Approval of details reserved by condition imposed under LU/182/18/PL relating to conditions 8-details showing set up during construction, 11-surface water drainage & 12-existing and resulting ground levels & slab levels of buildings.

46A & 46B Pier Road Littlehampton BN17 5LW

Arun District Council have decided to **APPROVE IN PART details reserved by condition**

Existing site and roof plan Scale 1:200 @A3

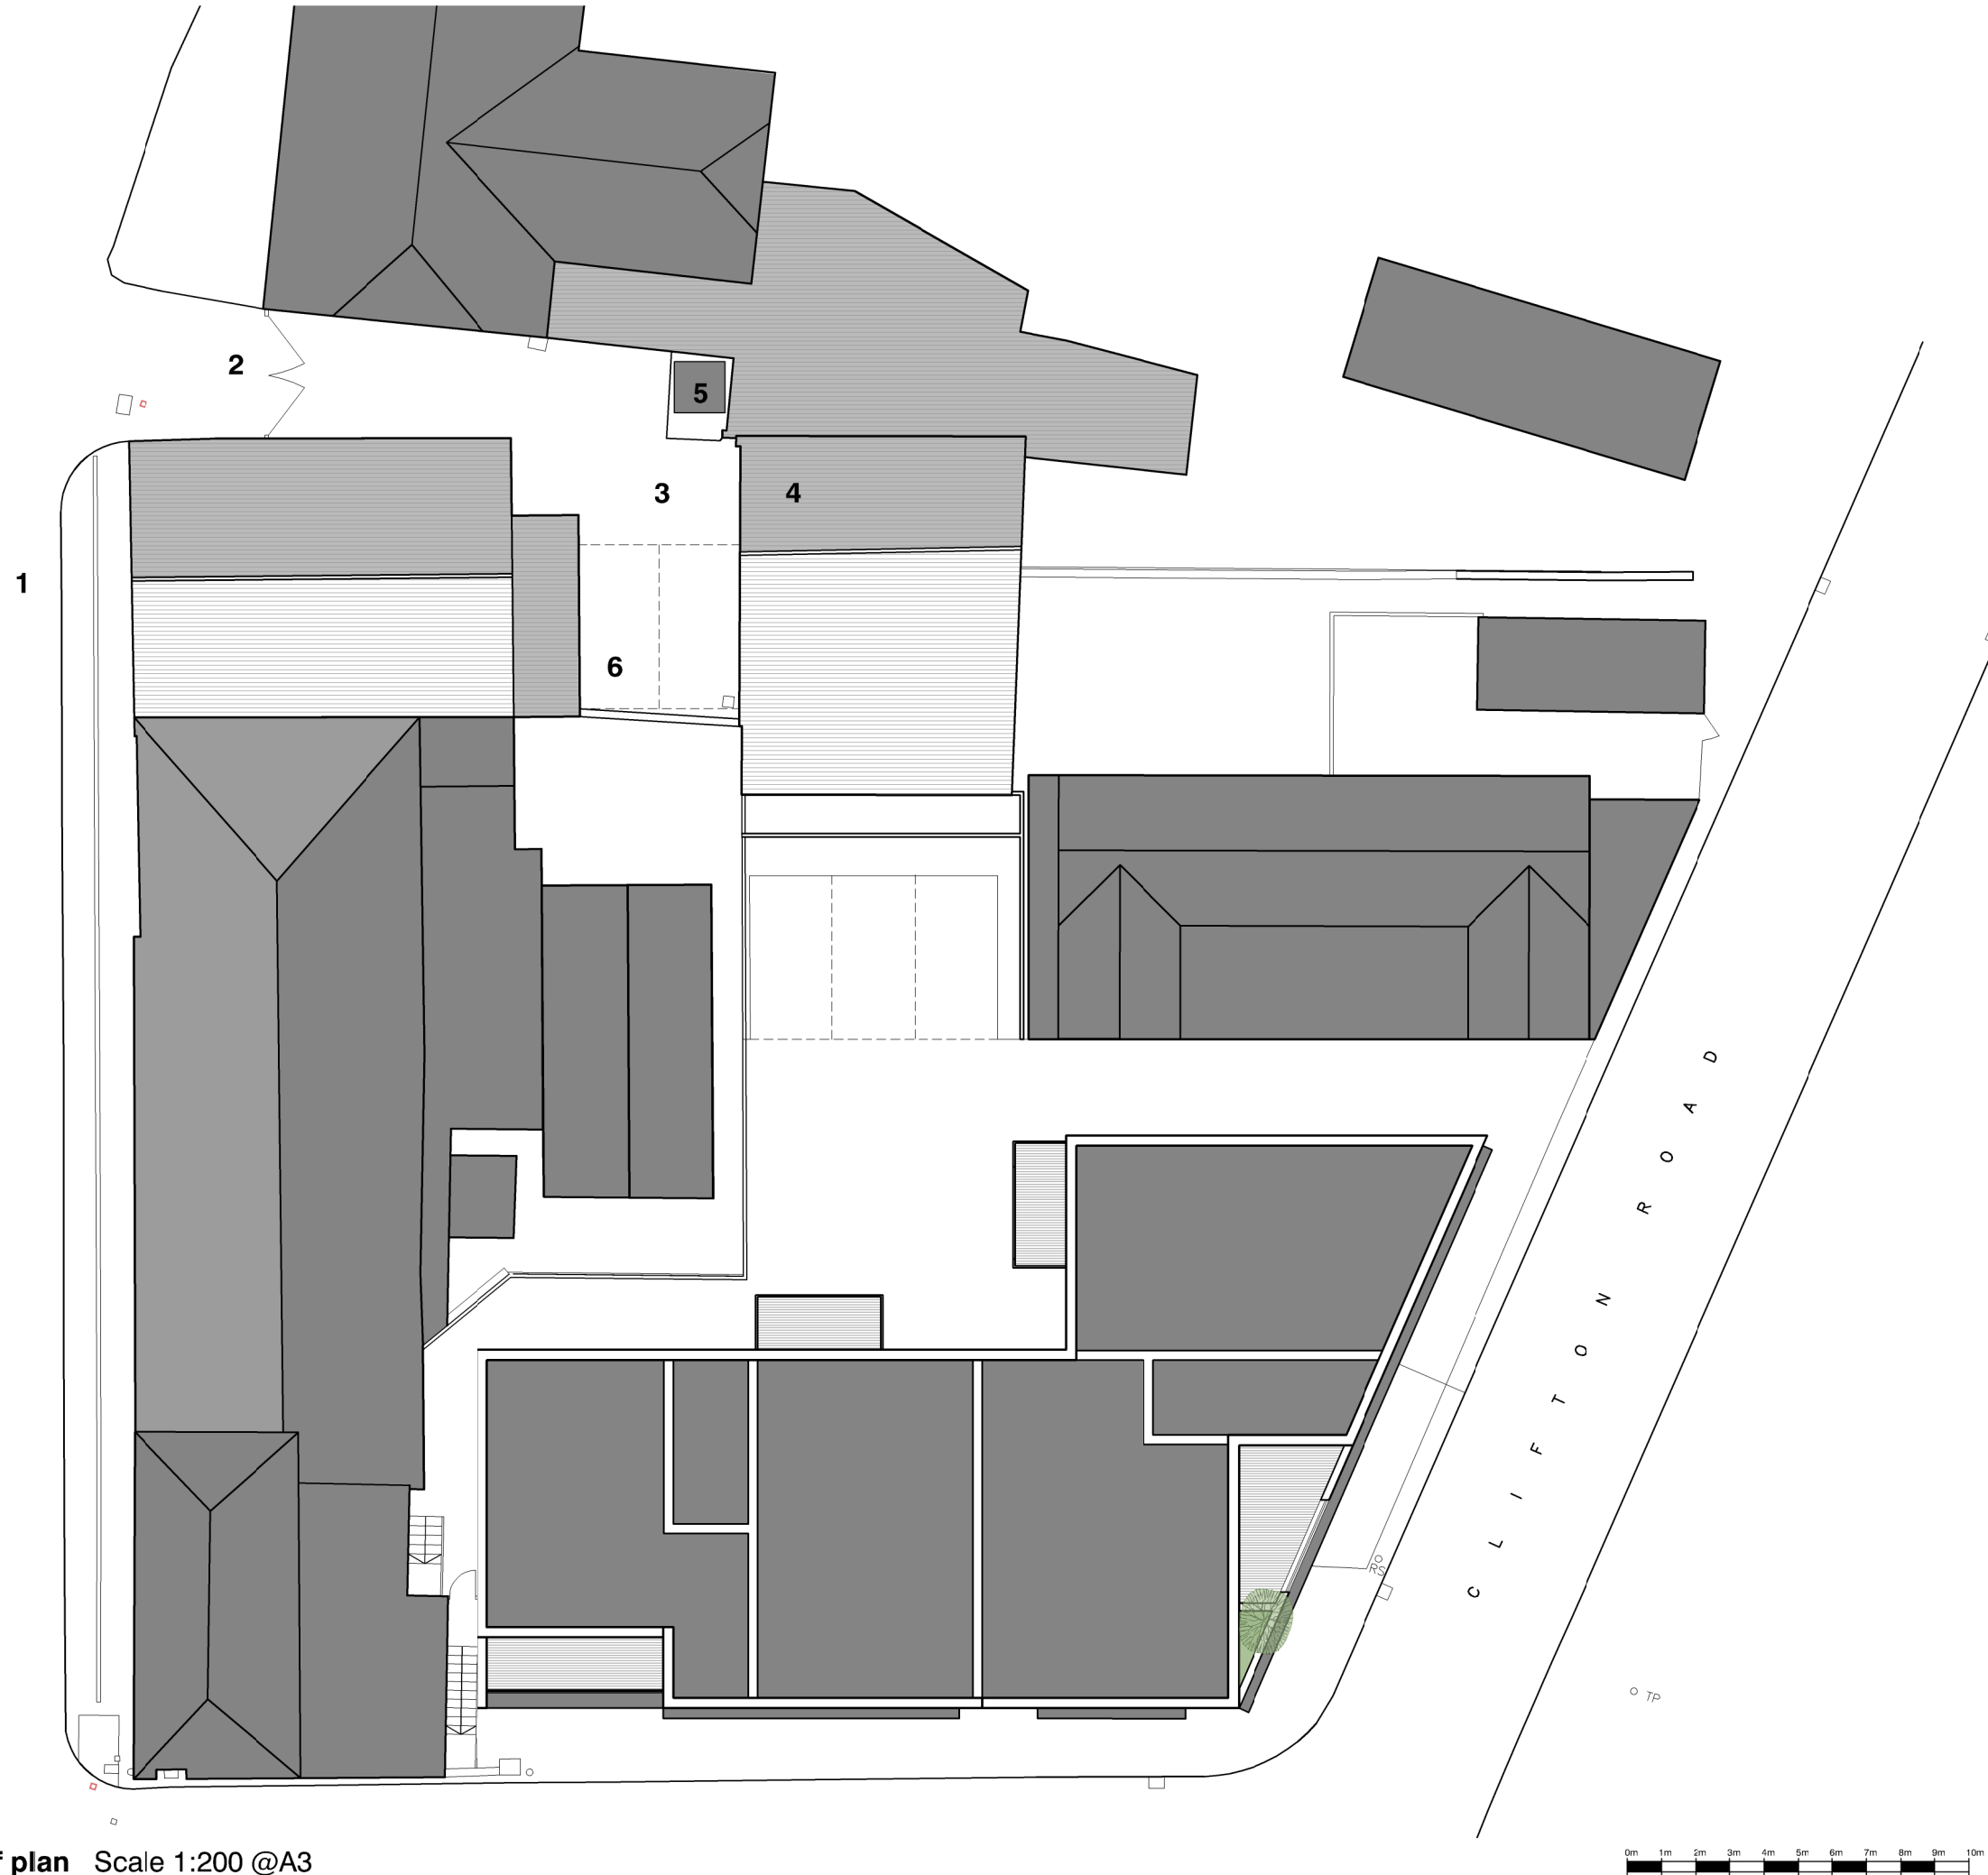
The proposed site set up plan demonstrates that temporary parking of contractors vehicles will be within the rear courtyard area. In principle the Local Highway Authority (LHA) is satisfied with this arrangement, but would request that a banksman be on site at all times to assist with safe traffic and pedestrian movements during loading/unloading of vehicles. As above, the LHA is satisfied in principle, but requests confirmation from the applicant that a banksman will be provided which will enable this condition to be fully discharged.
